Kilkenny County Council

Re: ABP-322225-24 (24/60210)

Permission for development. The development will consist of: (i) All works (within County Kilkenny) associated with the connection of the proposed Seskin Wind Farm to the national electricity grid, via underground 38kV electrical cabling within the public road corridor to the existing Kilkenny 110kV substation; (ii) Provision of 16 no. joint bays, communication chambers and earth sheath links along the underground electrical cabling route; (iii) Reinstatement of the road and track surfaces above cabling trench along existing roads and tracks; (iv) Carriageway strengthening works at 'Black Bridge' on the L1835 / L3037 (Protected Structure RPS Ref. D84); (v) A new temporary access road off the N78 to the L30372 in the townlands of Cloneen, Co. Kilkenny to facilitate the delivery of turbine components and other abnormal loads; (vi) All ancillary apparatus and site development works above and below ground at Kilmagar, Clara Upper, Mountnugent upper, Mountnugent lower, Ossoryhill, Feathallagh Churchclara, Rathgarvan or Clifden, Clarabricken, Coolgreany, Coolcullen, Reevanagh, Scart, Highrath, Ballysallagh, Ballynamona, Coan East and

Figure 15-7a Proposed grid connection route

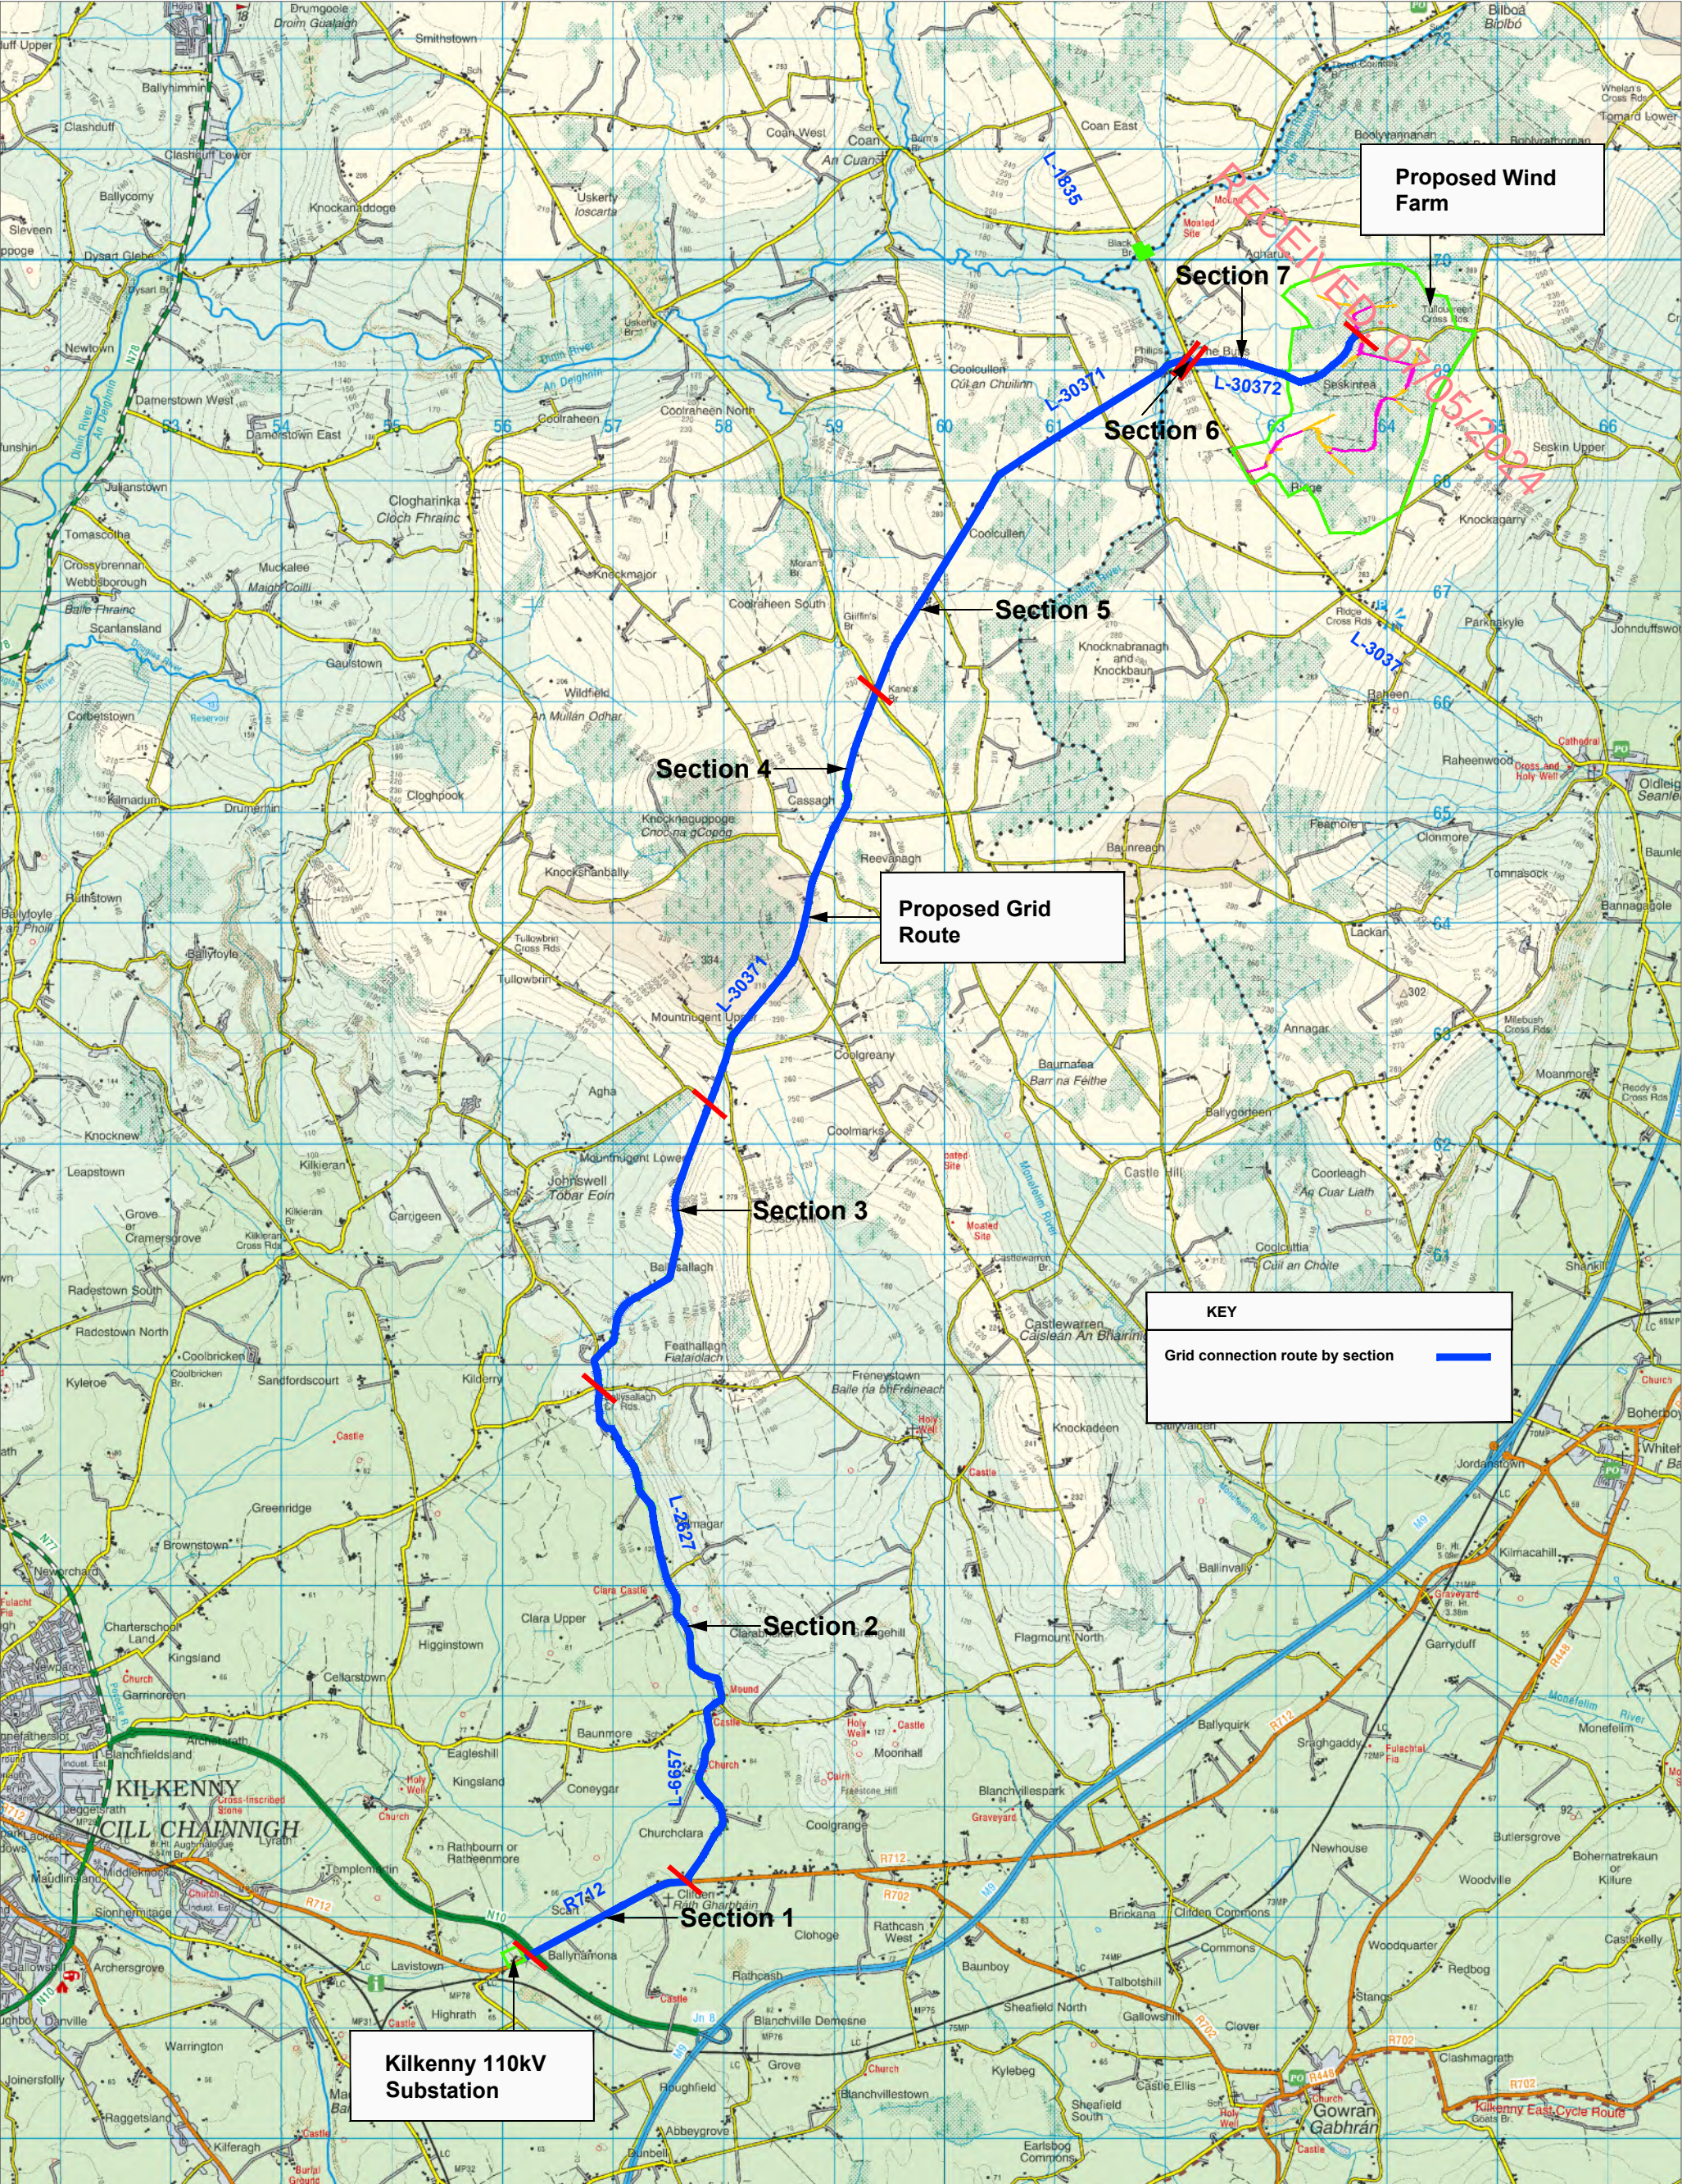
In relation to the first party appeal to the above referenced planning application, An Bord Pleanála are advised that the main areas of concern relate to the grid connection route selection process and the potential significant impacts in particular on the road infrastructure itself and its carrying capacity, and the potential impacts on the receiving environment and on the residential amenities as a result of the proposed grid connection works. This is summed up in the recommendation of the Planning Authority which states:

In addition, it is considered that the applicant has failed to adequately address the potential impacts of the proposed grid connection in particular, the lack of alternative grid connection routes assessed such as overhead cables and connection via third party lands, to ensure that the optimal route has been selected which would not have a detrimental impact on the environment, the public road network or local amenity. There is no consideration given to the effect of the ducting of cables under a public roadway on the carrying capacity of the roadway for other services, including potential demand from other energy projects. The significant environmental effects, including effects on material assets, noise, hydrology, biodiversity, amenity, nuisance and cumulative effects, the lack of information on alternative grid connection routes and comparison of their environmental effects have not been adequately addressed in the submitted EIAR.

Having regards to planned grid connection infrastructure and other potential windfarm/solar/energy schemes in the area, there is concern that there will be separate ducting runs for each operation which will severely limit the public road capacity and the Local Authority's ability to carry out its functions in respect to maintenance works and future services provision. There is significant merit in rationalising the ducting and grid connection infrastructure to cater for all the different parties/developments. In particular, the crossing of culverts structures and the ducting in the R712 should be rationalised. The applicant has identified that the proposed grid connection route will utilise the same route corridor over a portion of the grid connection route as other proposed grid connections either in development or planning stage.

It is unclear if the ESBN design review and detailed analysis was fully undertaken in respect of the route selection and route risk assessment having regard to the changes in availability of existing OHL infrastructure, the limited engagement with TII in respect of the traversing the N10 and R712 for Route Options 1-KK and 2-KK, and the impact of grid connection roadworks in terms of duration and traffic diversion route and impacts on the travelling public raised by third party submissions. Furthermore, the risk of being unable to obtain a Road Opening

Licence due to lack of capacity in the road network due to other potential grid connection installations does not appear to have been fully addressed in this instance.

Figure 15-7c Proposed grid connection route - Diversion for Section 3

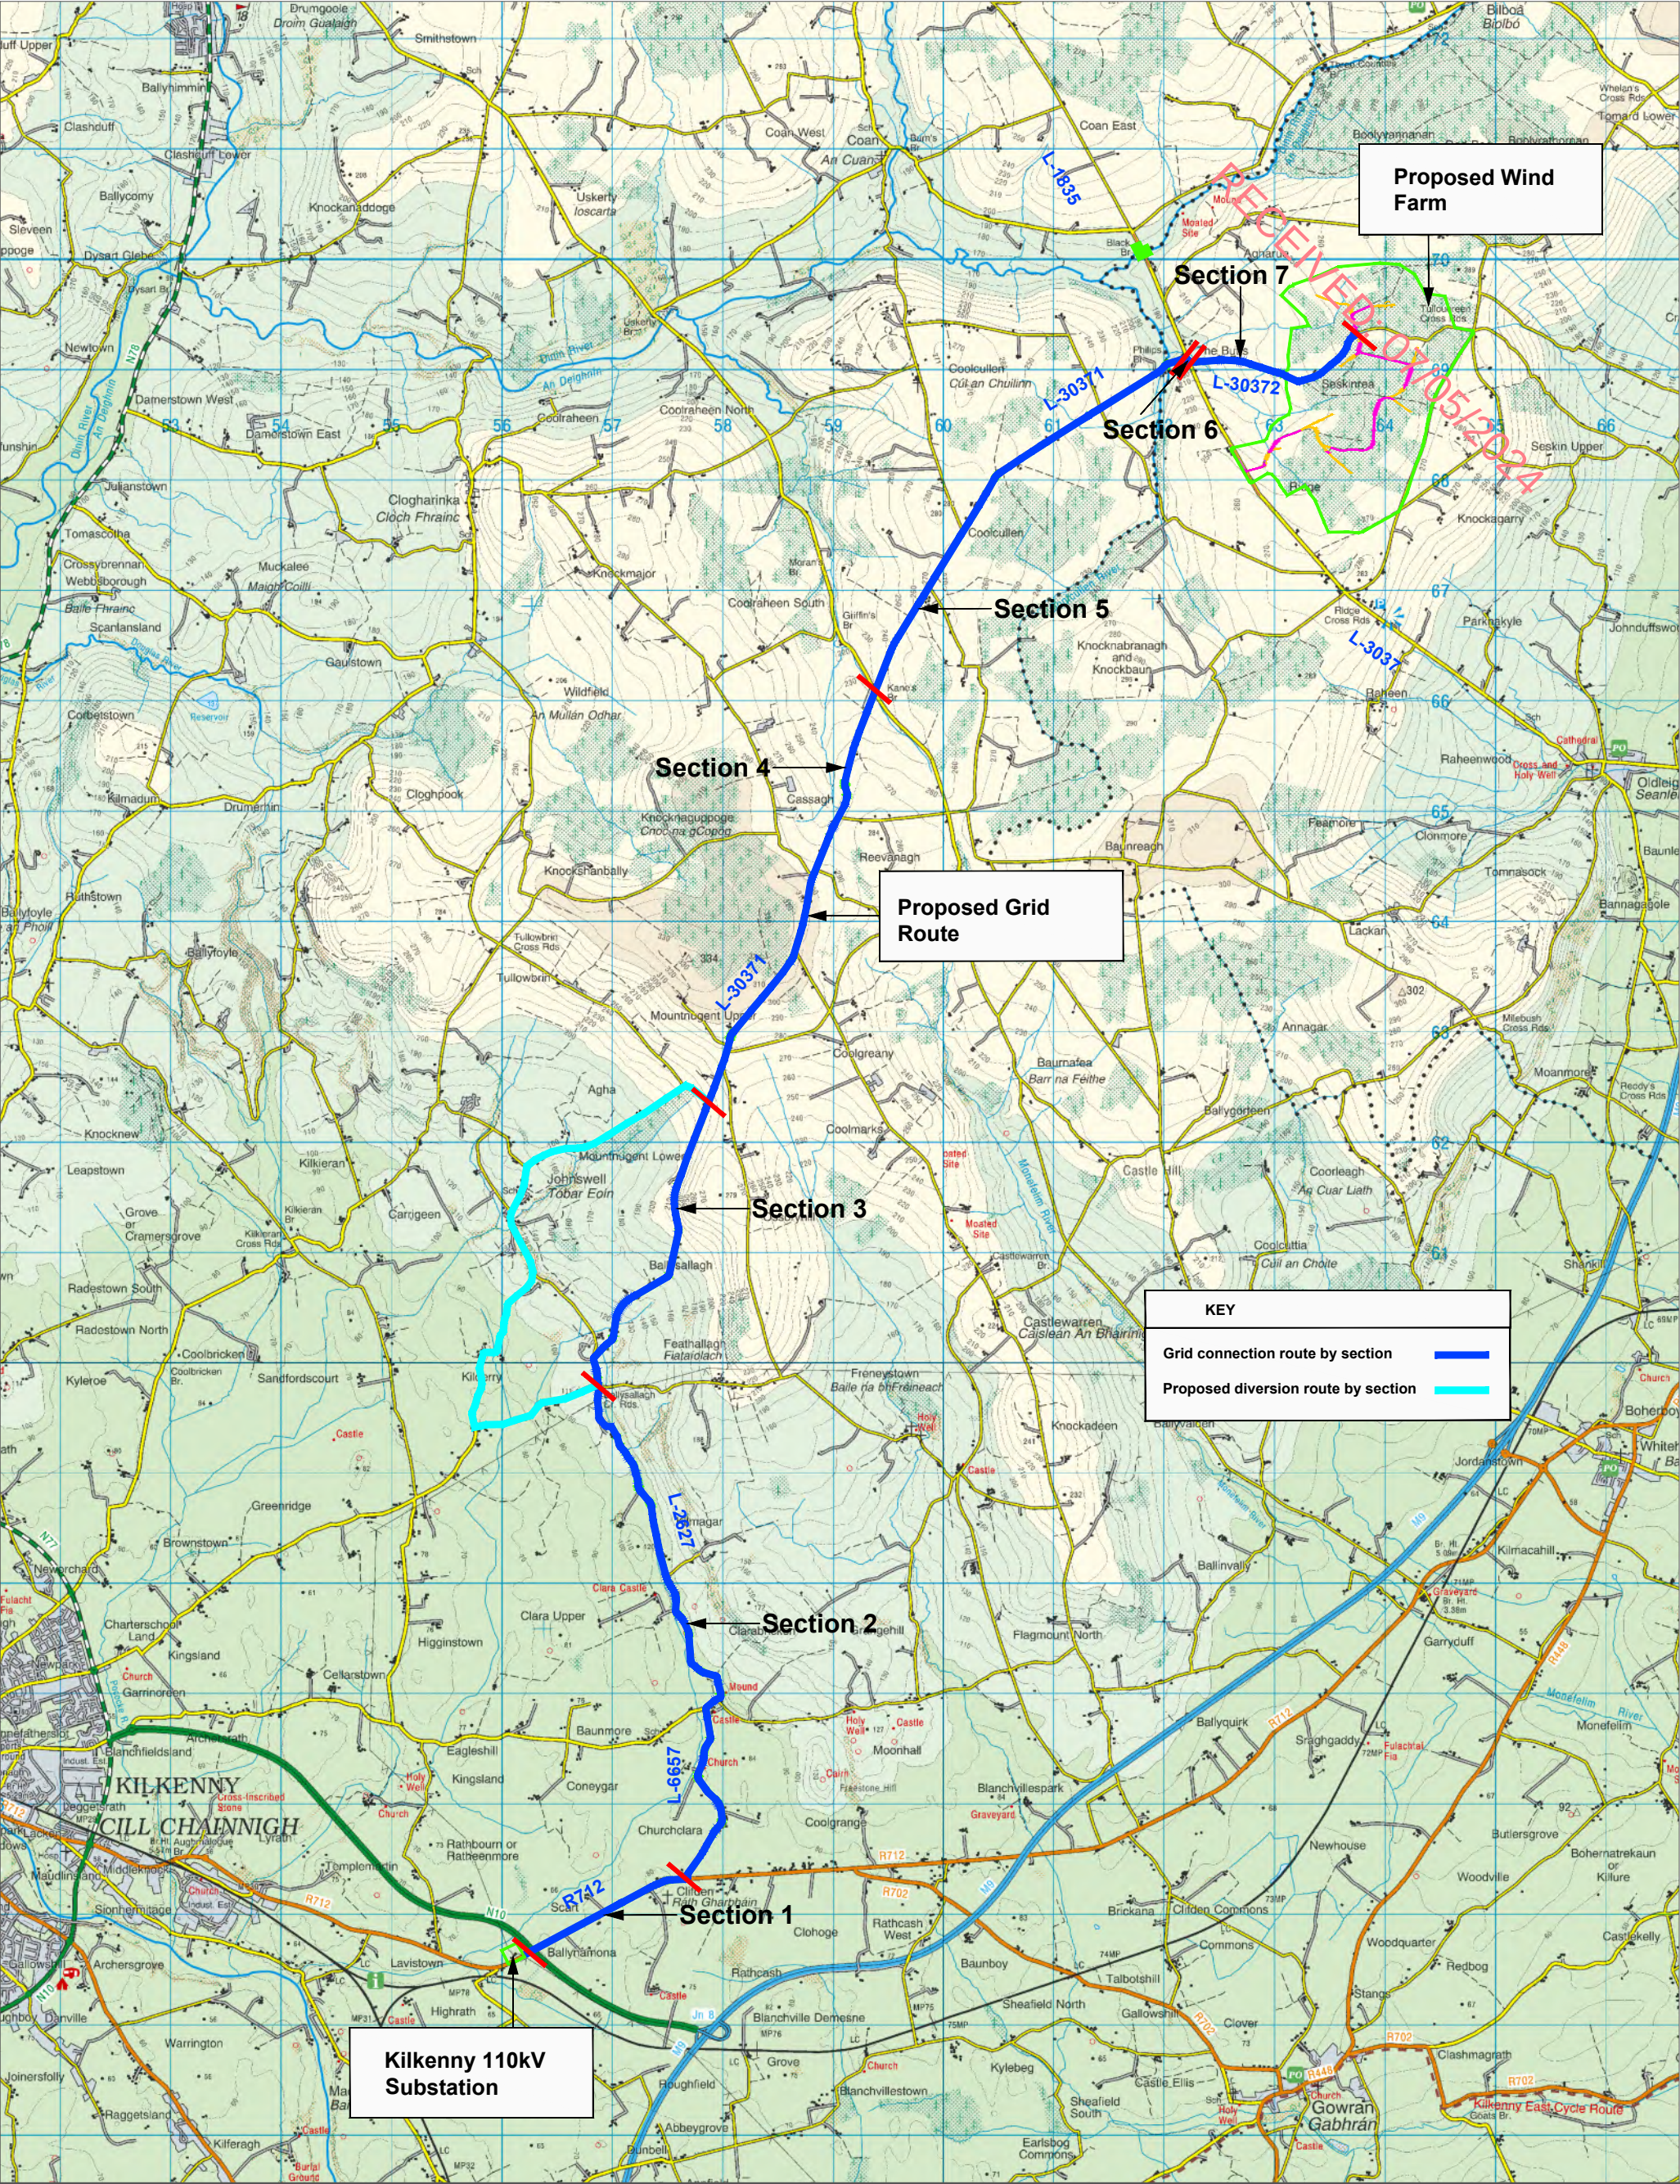
The applicant indicates that traffic volumes will significantly increase on the proposed traffic diversions over extended periods (8-10 weeks for a number of diversions) with an overall time frame of approximately 10-12 months (221 construction days) of consecutive diversions over

the extent of the grid connection. Projected additional vehicle detour distances travelled are estimated at 221,122 kms over this period with detour additional lengths ranging from 1.5 to 7.2 km and increased average trip times of approximately 4 minutes.

The applicant has not provided information regarding the suitability of the roads for traffic diversion in terms of structural capacity and cross-section to cater for diverted traffic for the anticipated closure periods. Proposals for carriageway improvements, road-widening/passing bays, junction improvements, signage and any other relevant traffic management controls have not been provided as requested. The applicant has indicated that this would be done post planning at detailed design/road opening licence stage.
